1 August 2025

TfNSW reference: REN25/00108/002

SSD-8911, Sundown Solar Farm, Sturmans Road, Spring Mountain NSW 2360; Response to Response to Submissions (RTS)

Transport for NSW (TfNSW) is responding to the Sundown Solar Farm Response to Submissions, referred on 30 June 2025 via the Major Projects Portal.

Figure 1. Gwydir Highway / Spring Hill Mountain intersection upgrade

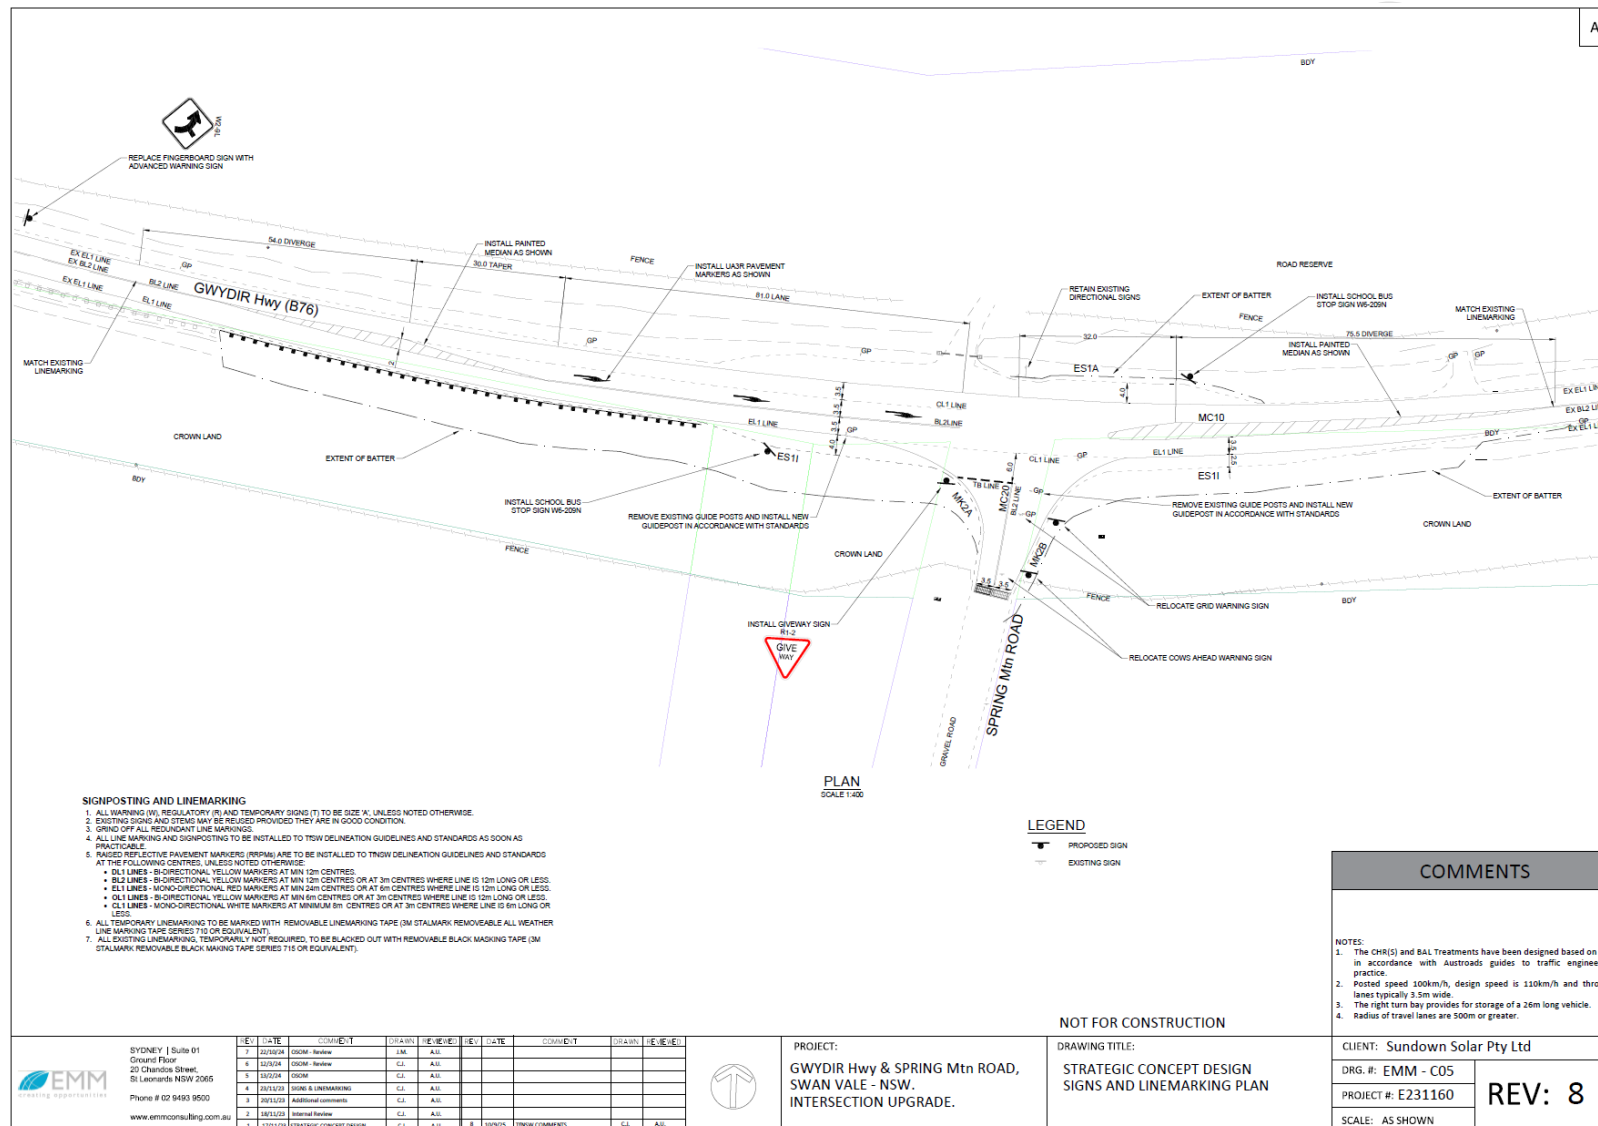
8.	There is an existing school bus stop located at the Gwydir Highway/Spring Mountain Road intersection (with no signage or infrastructure). The proposed bus stop facilities need to be shown within the plans considering safety and further information detailing the proposed measures to prevent conflict with vehicles travelling through the intersection is needed.	Partially closed: Appendix H DRG EMM-C05 indicates that school bus signs are to be installed. However, strategic concept designs are to be provided for the pedestrian refuge area to be relocated at 3081 Gwydir Highway. Confirm if the painted medians in DRG EMM-C05 are for the pedestrian refuge islands mentioned in Section 12 of the interim CTMP.

9.	The fingerboard sign on the eastbound approach to the intersection on the Gwydir Highway should be replaced by an Advance Intersection Warning Sign, the plans need to be updated to demonstrate this.	Open: Appendix H DRG EMM-C05 indicates that the existing fingerboard sign is to be replaced with an Advance Intersection Warning Sign. However, the Submissions Report states that the fingerboard will be retained, and an Advance Warning Sign is to be installed 80 – 100m west of the intersection. Clarification is required.

10.	Appendix B includes a 2D layout over an aerial image. A strategic design is required which must be to scale and include, but not be limited to details on, legal property boundaries including the existing road reserve boundaries, existing and proposed ground levels, existing and proposed lane configurations, existing and proposed lane widths, new lane lengths, typical cross sections, conceptual drainage details (for any changes required), proposed signage, impacts to utilities &/or signage etc.	Partially closed: Proposed drainage details have not been provided. Further comments on strategic design are included in Appendix 2 of this response.

2.	Appendix H: Intersection Design- Spring Mountain Road/Gwydir Highway- requested revisions The strategic concept designs for the Spring Mountain Road/Gwydir Highway are to be revised to address points a) to e). a. Ensure all notes are updated to reflect TfNSW guidelines, from the antiquated RMS guidelines. b. DWG EMM-C05: i. Line marking type shown (e.g. C1 Line) does not comply with the revised TfNSW technical directive TS 05462. Notation is to be updated to suit this standard. ii. A bus stopped in WB bus bay may encroach the intersection approach lane of Spring Mountain Road. Provide swept paths of buses to demonstrate appropriate space. iii. Interface string is missing which makes it difficult to determine the designs proposed footprint. Include in the revised TIA. c. DWG EMM-C06 i. Interface string is missing which makes it difficult to determine the designs proposed footprint. Include in the revised TIA. ii. Clarify the pavement treatment for the proposed widening of the Gwydir Highway. d. DWG EMM-C07 i. No vertical curves are designed on any of the profiles. Include in the revised TIA. ii. Vertical profile missing for the mainline of the Gwydir Highway. Include in the revised TIA. e. DWGs EMM-C08 to EMM-CO11 i. Crossfall data and design data are missing on several cross sections. Include in the revised TIA. ii. String naming conventions for the Gwydir Highway cross sections do not match TfNSW specifications. iii. Barrier is missing in cross sections. iv. It is recommended to assess the risk of the large trees at the eastern end of the works at the toe of the high embankment to confirm if a barrier is required.
